Application No: 20/03391/DISC

Proposal : Discharge of Conditions 19 (Ecological Management Plan), Con 23 (Hard Landscaping), Con 24 (Hard Landscaping), Con 29 (Streetlighting), Con 30 (Fire Hydrants), Con 31(Travel Plan), Con 32(Public Artwork), Con 36(On street parking controls) and Con 37 (public infrastructure) of 15/01326/OUT - up to 280 residential dwellings (including up to 30% affordable housing), introduction of structural planting and landscaping, informal public open space and children's play area, surface water flood mitigation and attenuation, vehicular access point from White Post Road and associated ancillary works

Location: OS Parcels 6741 And 5426 West Of Cricket Field Nor, Wykham Lane, Bodicote

## Transport Development Control

TITLE:	Section 278 Adoptable Highway Traffic Restriction Plan
PROJECT:	White Post Road, Bodicote
DRG. No:	957-278-20

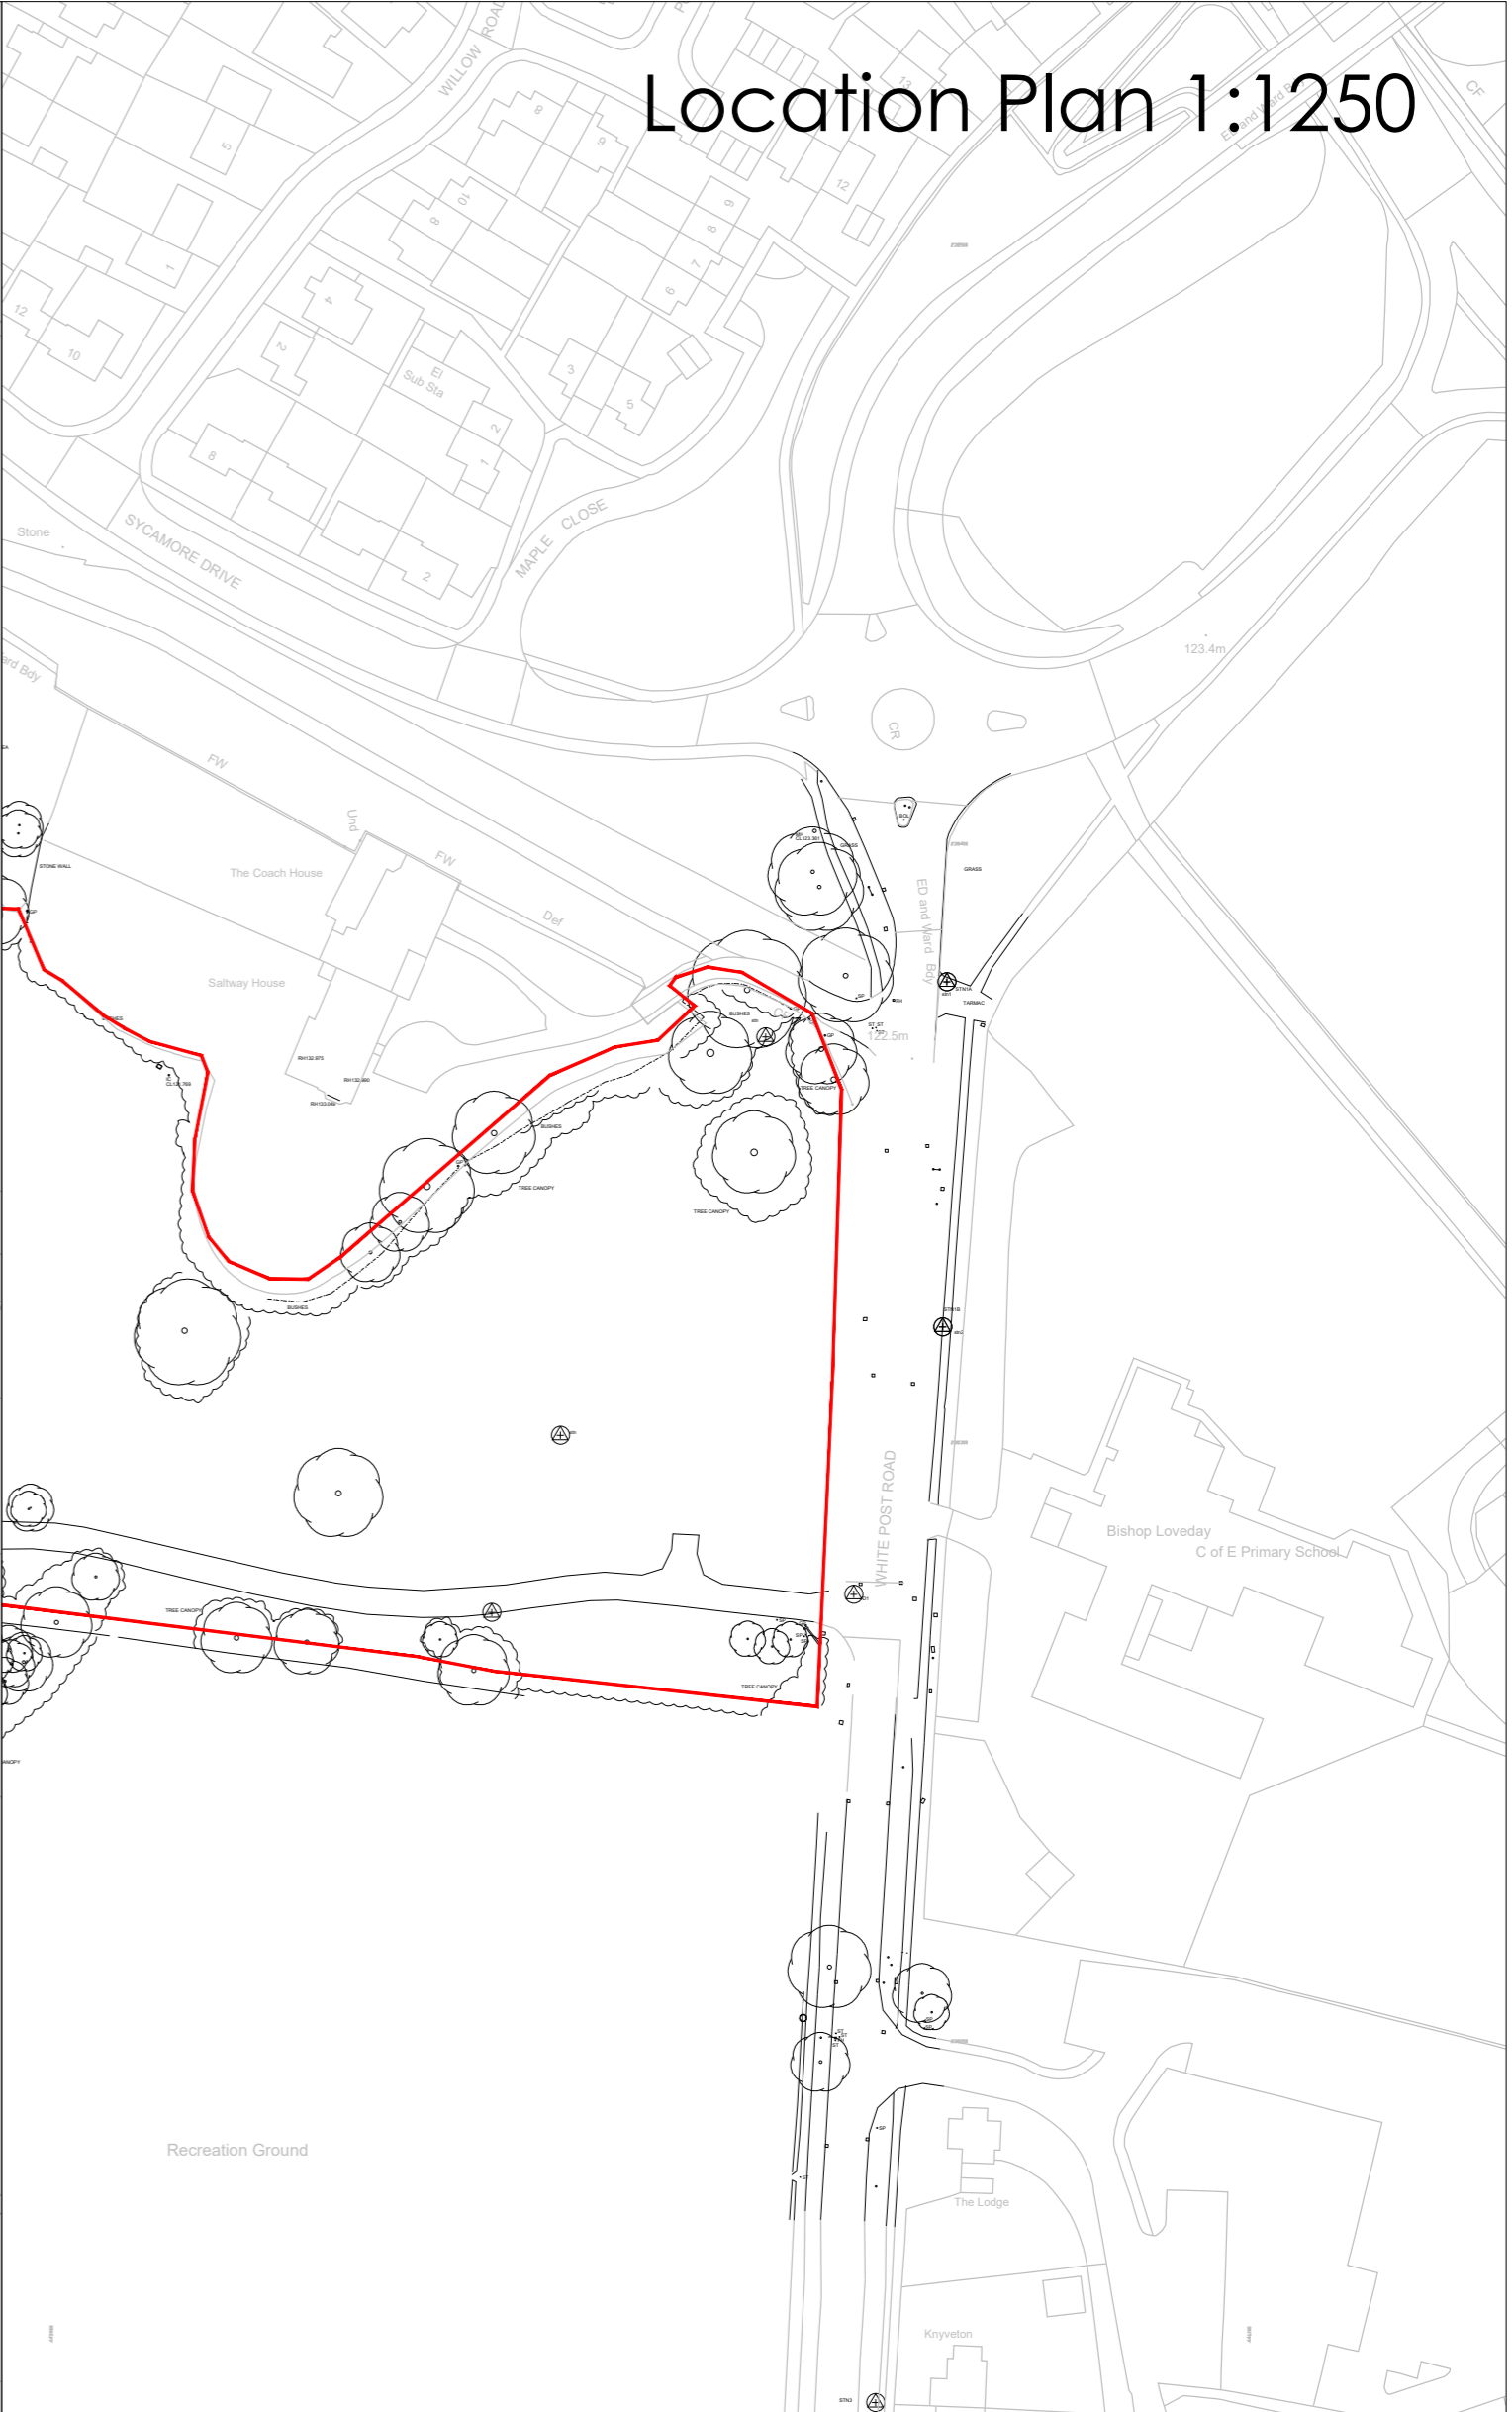
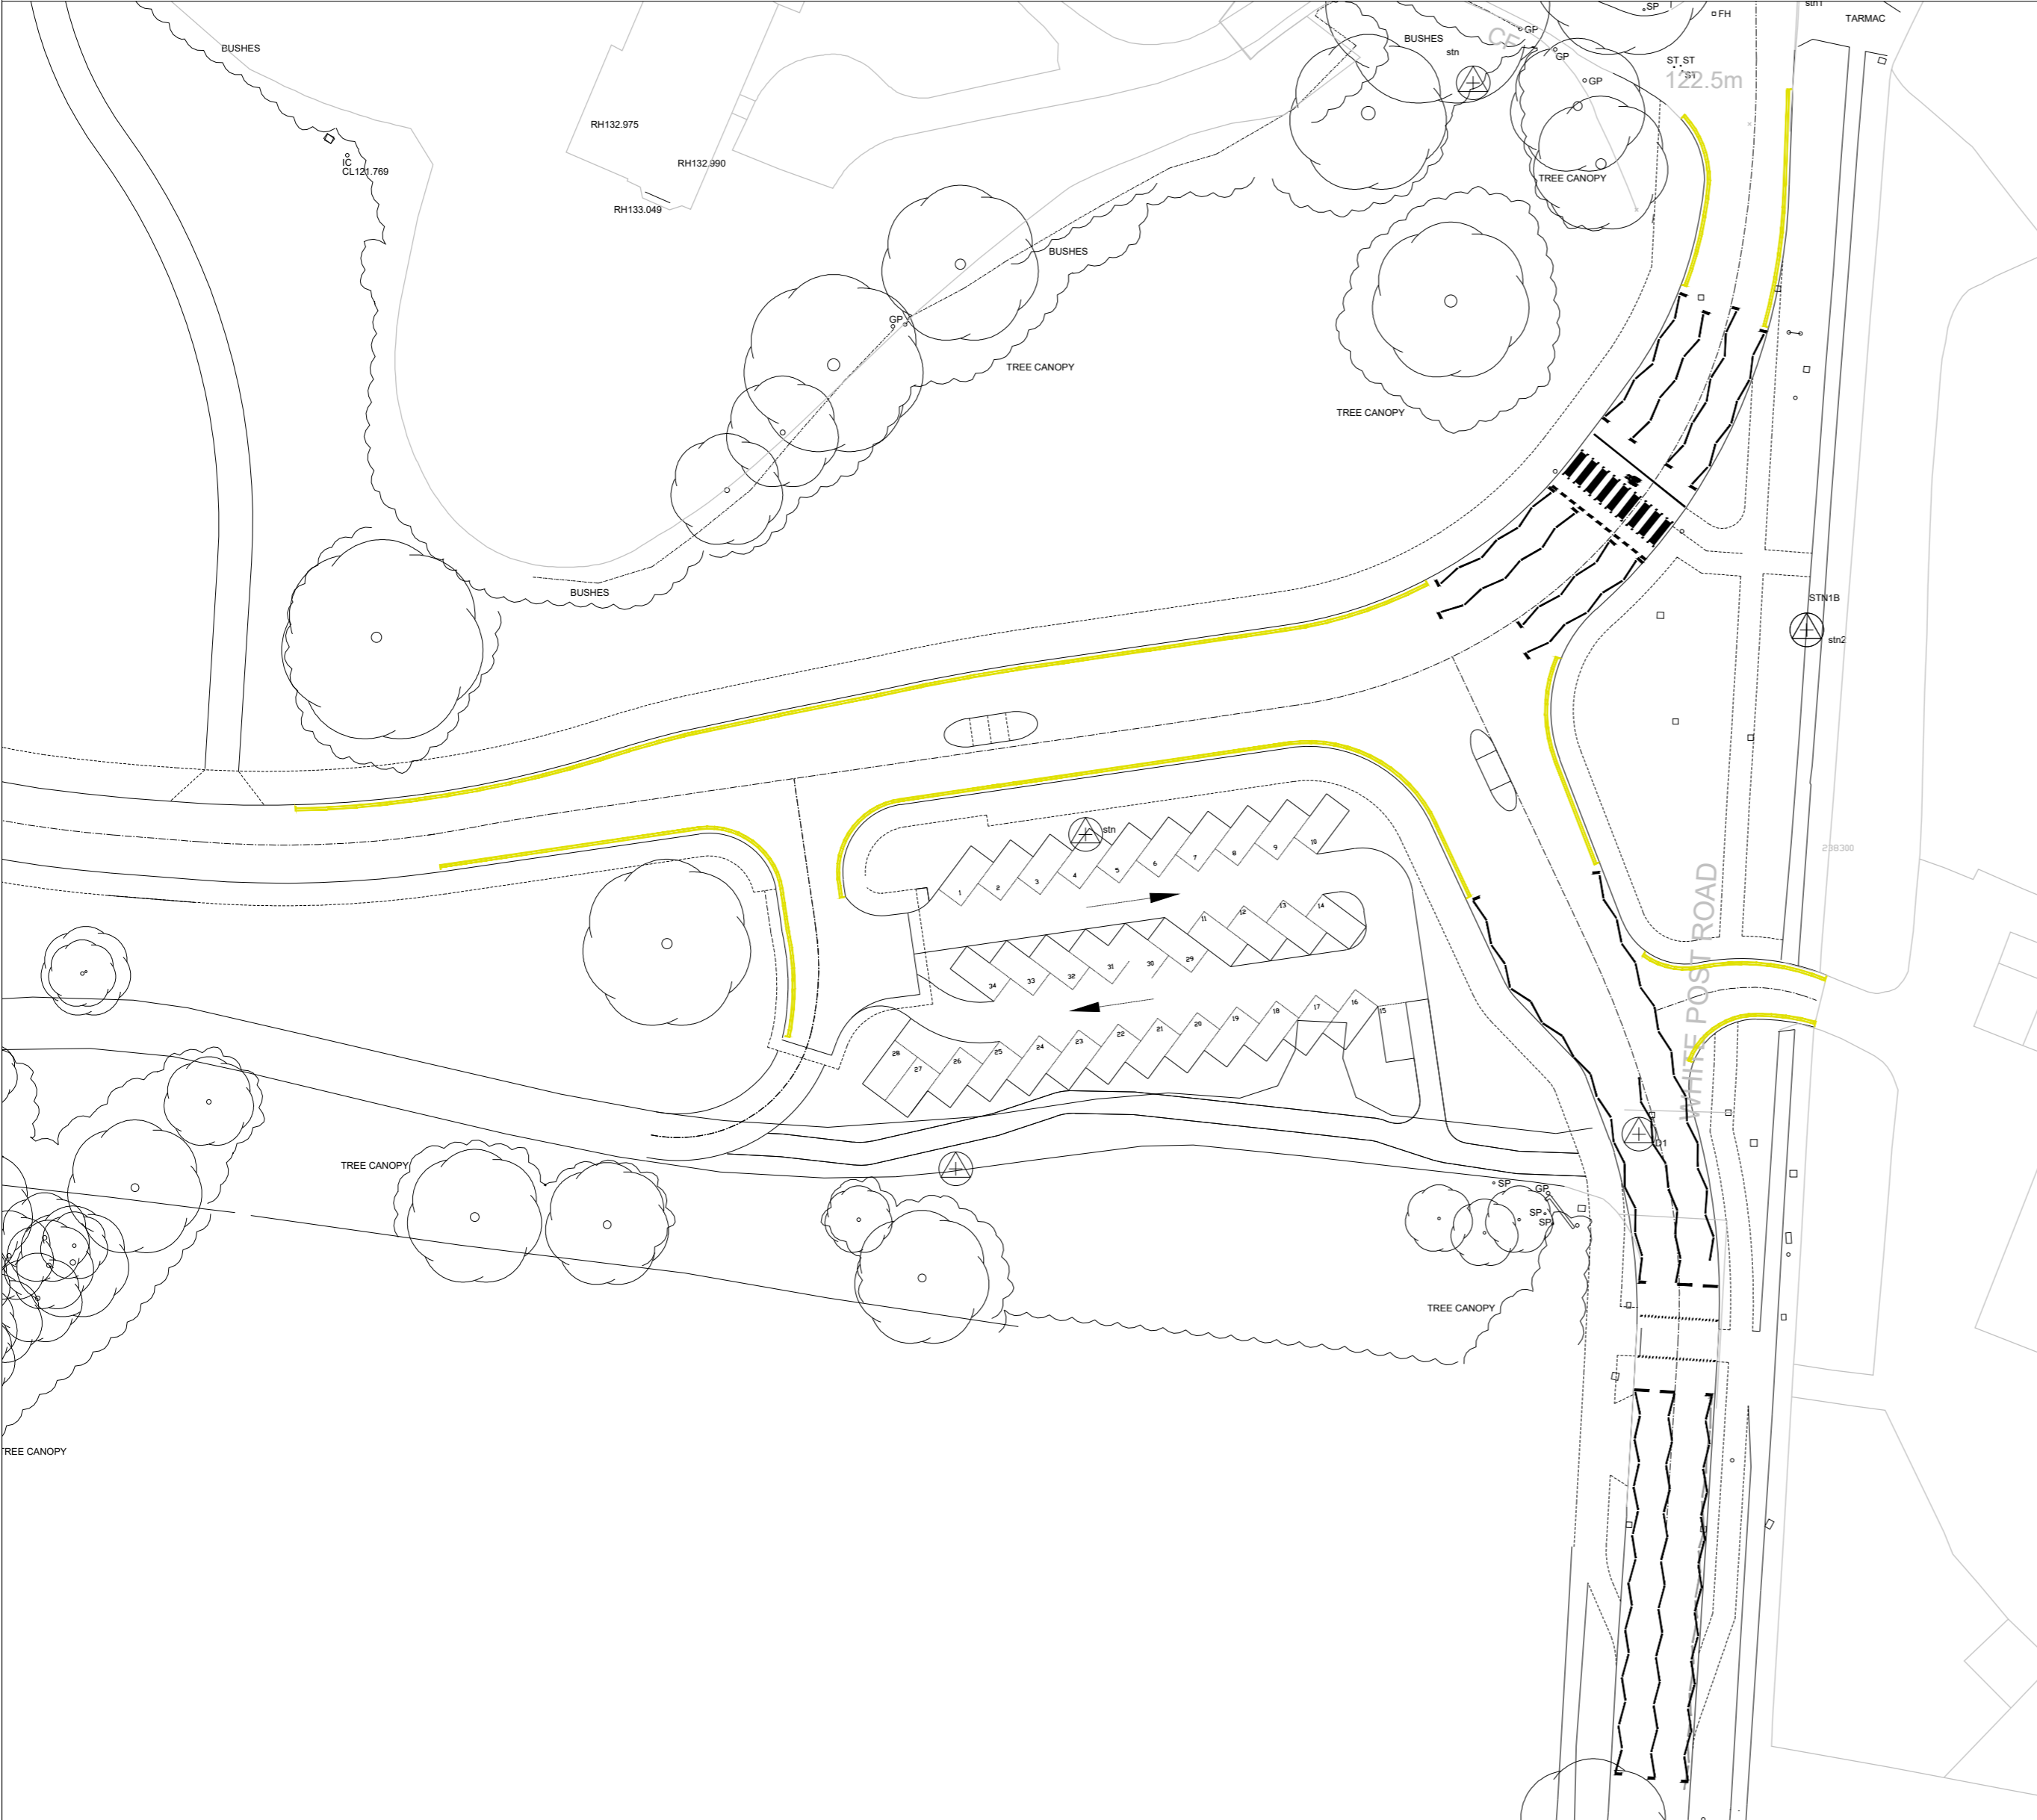
*Condition 24 (Hard landscaping (cycle tracks))*  
*Condition 29 (Street lighting)* – Drawing A4804b as designed by OCC street lighting team is acceptable.  
*Condition 36 (On street parking controls)* – Drwg No: 957-278-20 illustrates an acceptable scheme of parking control.
